Rezoning Transportation Analysis

Petition Number: 2025-092

General Location Identifier: 04324101, 04306213

Date	Description
09-24-25	First Review (KC)
10-23-25	Second Review (KC)
11-4-25	Trip Generation Update (DR)
11-25-25	Third Review (KC)

RZ-2

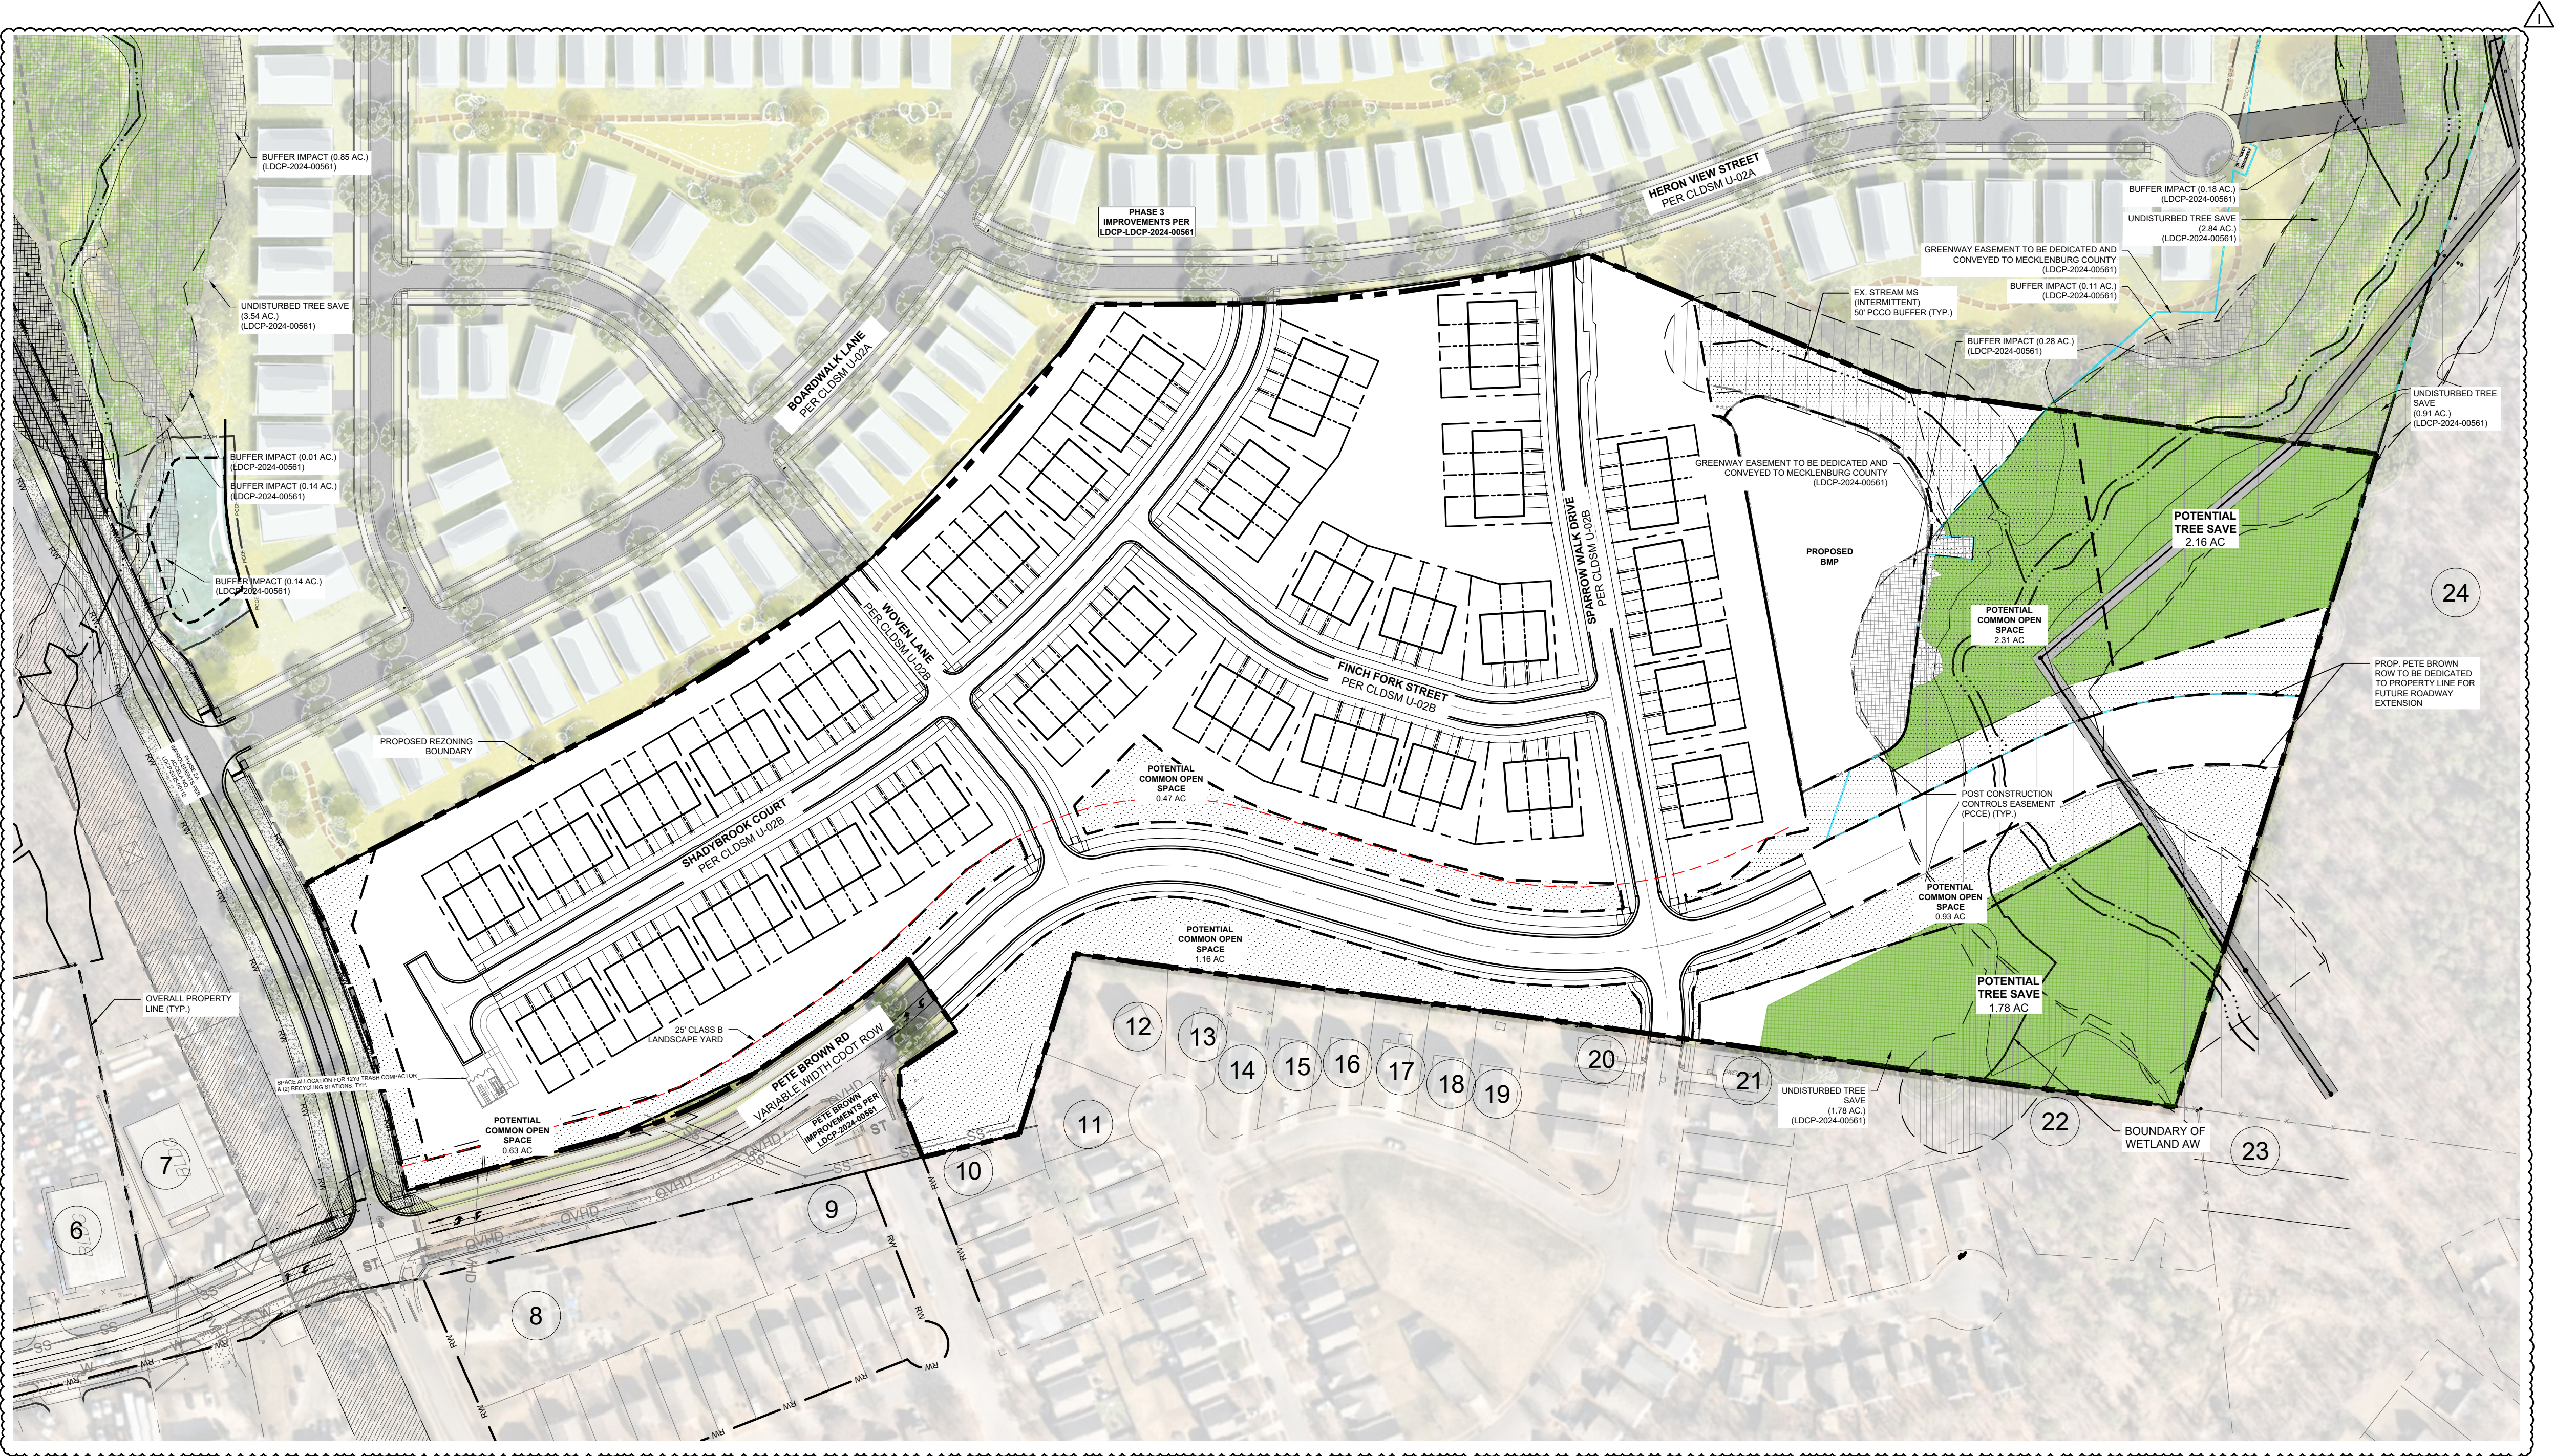
6. **New Comment 10-23-25:** ~~Revise site plan and conditional notes to construct 8' sidewalks along all internal roads per UDO and CLDSM U-02B. Revise site plan and conditional note(s) to reflect this requirement.~~
7. ~~Add a conditional note specifying "the Petitioner shall dedicate and convey in fee simple all rights-of-way to the City before the site's first building certificate of occupancy is issued. CDOT requests rights-of-way set at 2' behind back of sidewalk where feasible."~~
8. ~~Add a conditional note specifying "All transportation improvements will be approved and constructed before the site's first building certificate of occupancy is issued."~~

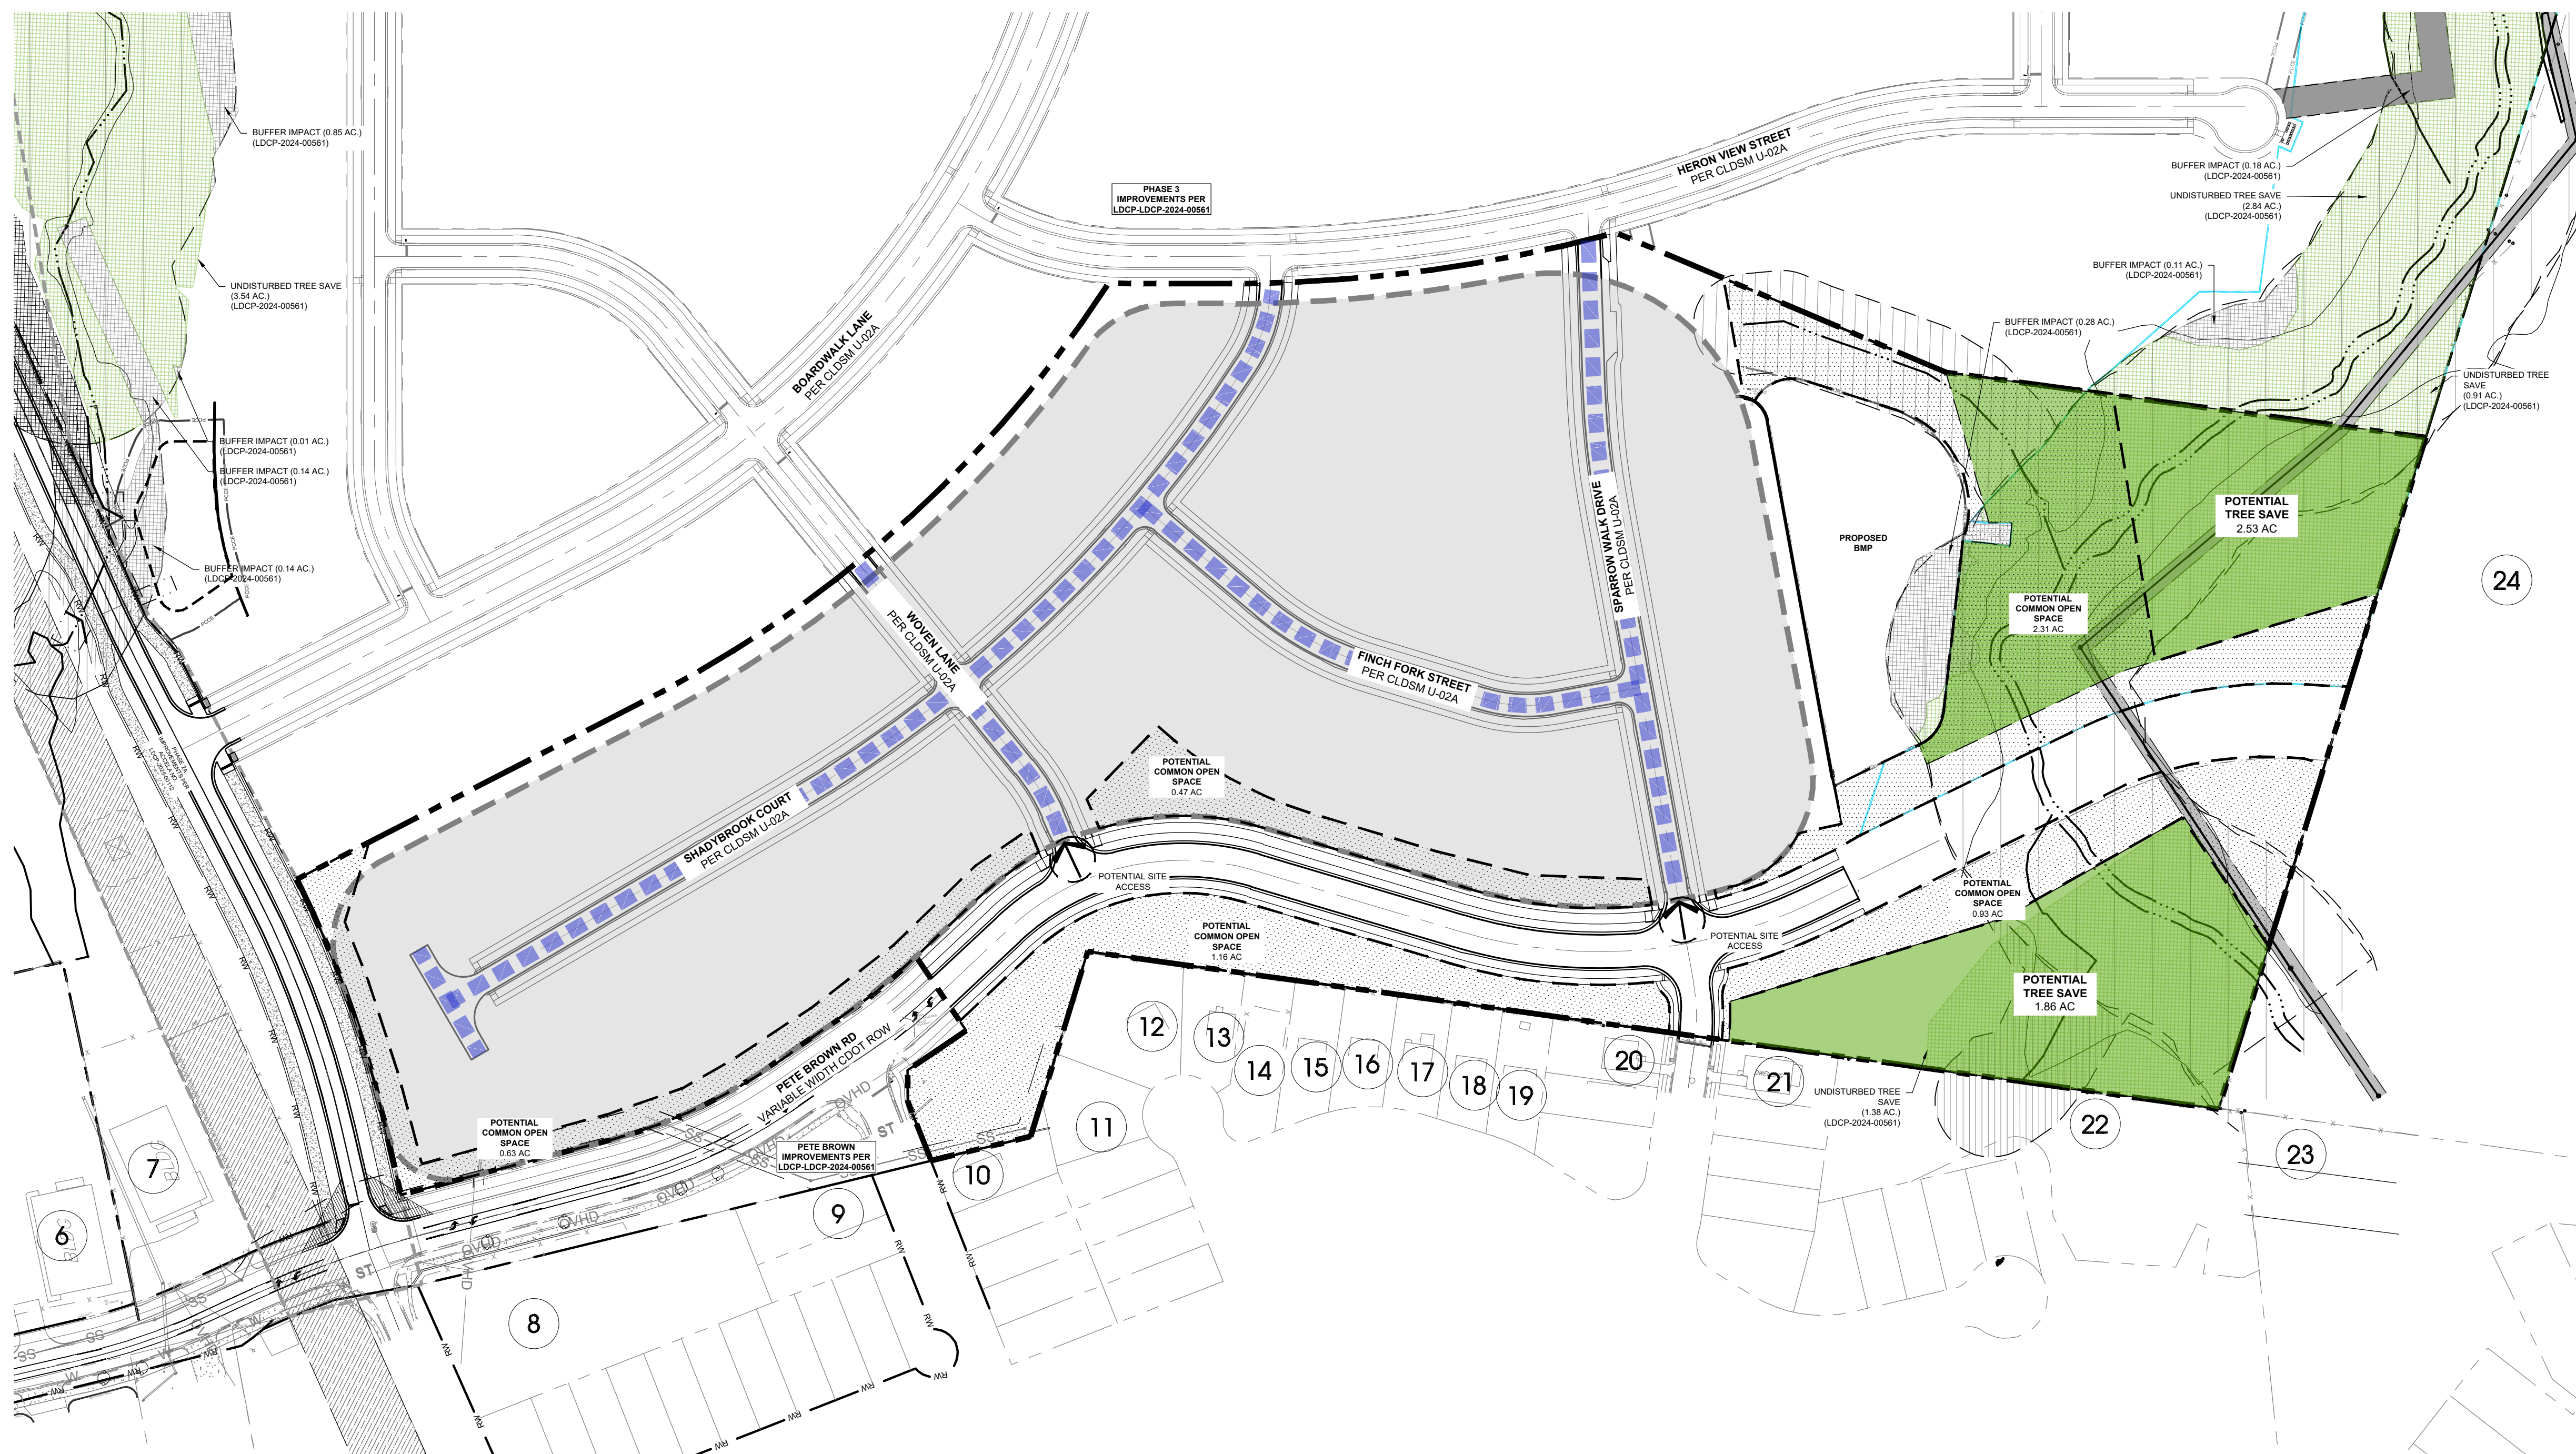
1. ~~Curbline:~~

a. ~~Pete Brown Road:~~ Location of future curb and gutter is to be located 27' from centerline.

~~2+ Avenue, Buffered/Separated Bike Lanes~~

~~Label and dimension the curb and gutter from the centerline for each road on the site plan.~~

3. **Comment Rescinded 10-23-25:** ~~Revise site plan and conditional note(s) to commit to dedicate 33.5' right-of-way from the road centerline. The site plan shall label and dimension the right-of-way from the road centerline for Shadybrook Court, Woven Lane, Finch Fork Street and Sparrow Walk Drive.~~

5. **Comment Rescinded 10-23-25:** ~~Revise site plan and conditional note(s) to commit to constructing Shadybrook Court, Woven Lane, Finch Fork Street and Sparrow Walk Drive as "Local Residential Wide Street" U-03A1.~~

After coordination with Subdivision internal network required public streets can meet Local Residential Medium standard and dedicate 27' right-of-way from the road centerline for Shadybrook Court, Woven Lane, Finch Fork Street and Sparrow Walk Drive.

After coordination with Subdivision internal network required public streets can meet Local Residential Medium standard for Shadybrook Court, Woven Lane, Finch Fork Street and Sparrow Walk Drive.
